DEPARTMENT OF PARKS AND COMMUNITY SERVICES

October 20, 2023

Subject: Retreat at TimberRidge Filing No. 3 Final Plat, Review #2 (SF-22-041)

619 N. Cascade Avenue, Suite 200
Colorado Springs, Colorado 80903 (719)785-0790

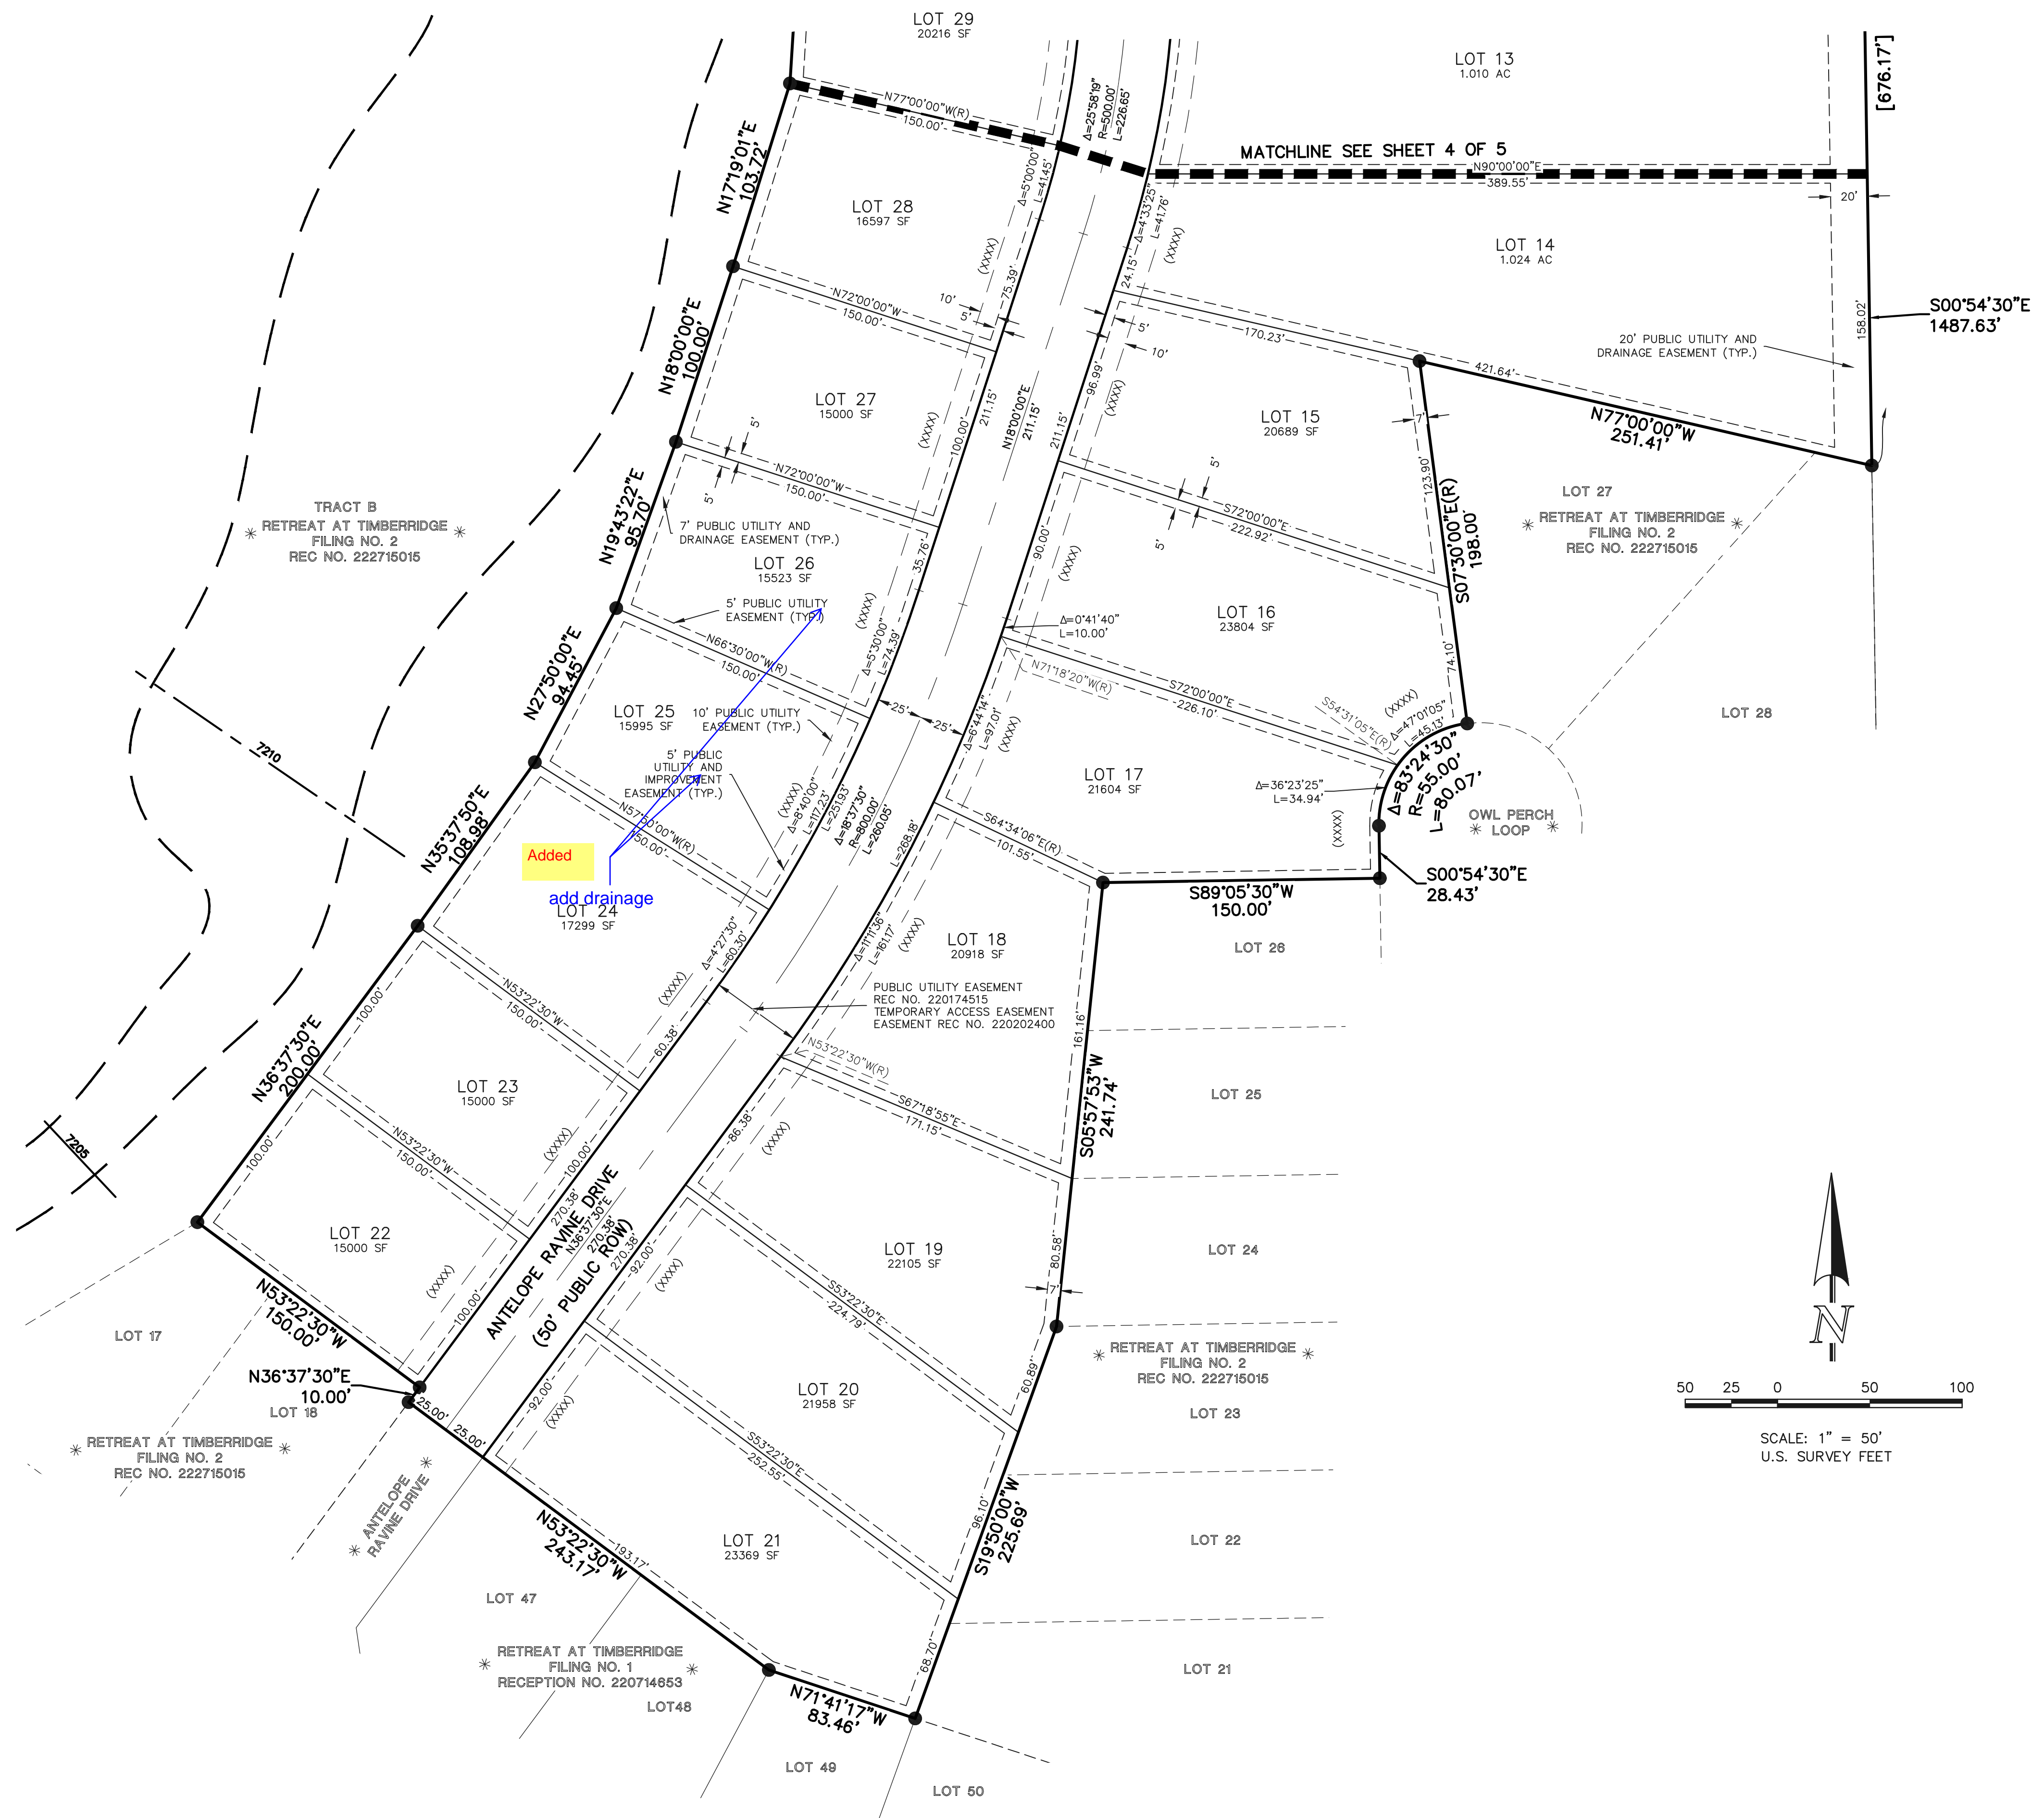
As noted in the comments and recommendations below and because Tracts A-D are to be owned by The Retreat Metropolitan District No. 1, the applicant must show and label the required 25' regional trail easements within the aforementioned Tracts. Staff understands that Tract H will be owned by El Paso County and therefore does not require the dedication of the regional trail easement, however, for continuity, the applicant may show a trail easement within Tract H.

The Retreat at TimberRidge Filing No. 3 Final Plat shows a 30' trail easement dedicated to the Sand Creek Regional Trail, running north-south on the west side of Sand Creek. According to the plat, this trail easement terminates at Arroyo Lane, and no additional trail easements are designated along Arroyo Lane, either east or west of Sand Creek. While the 2018 Retreat at TimberRidge Preliminary Plan did highlight the trail corridor along Arroyo Lane, only the Filing No. 3 Construction Drawings show what appears to be a trail along the south side Arroyo Lane. **If the Arroyo Lane Regional Trail easement is indeed located within Tracts A-D and outside of the designated Arroyo Lane right-of-way, the plan must be symbolized and annotated to show them in a clear and discernable manner.**
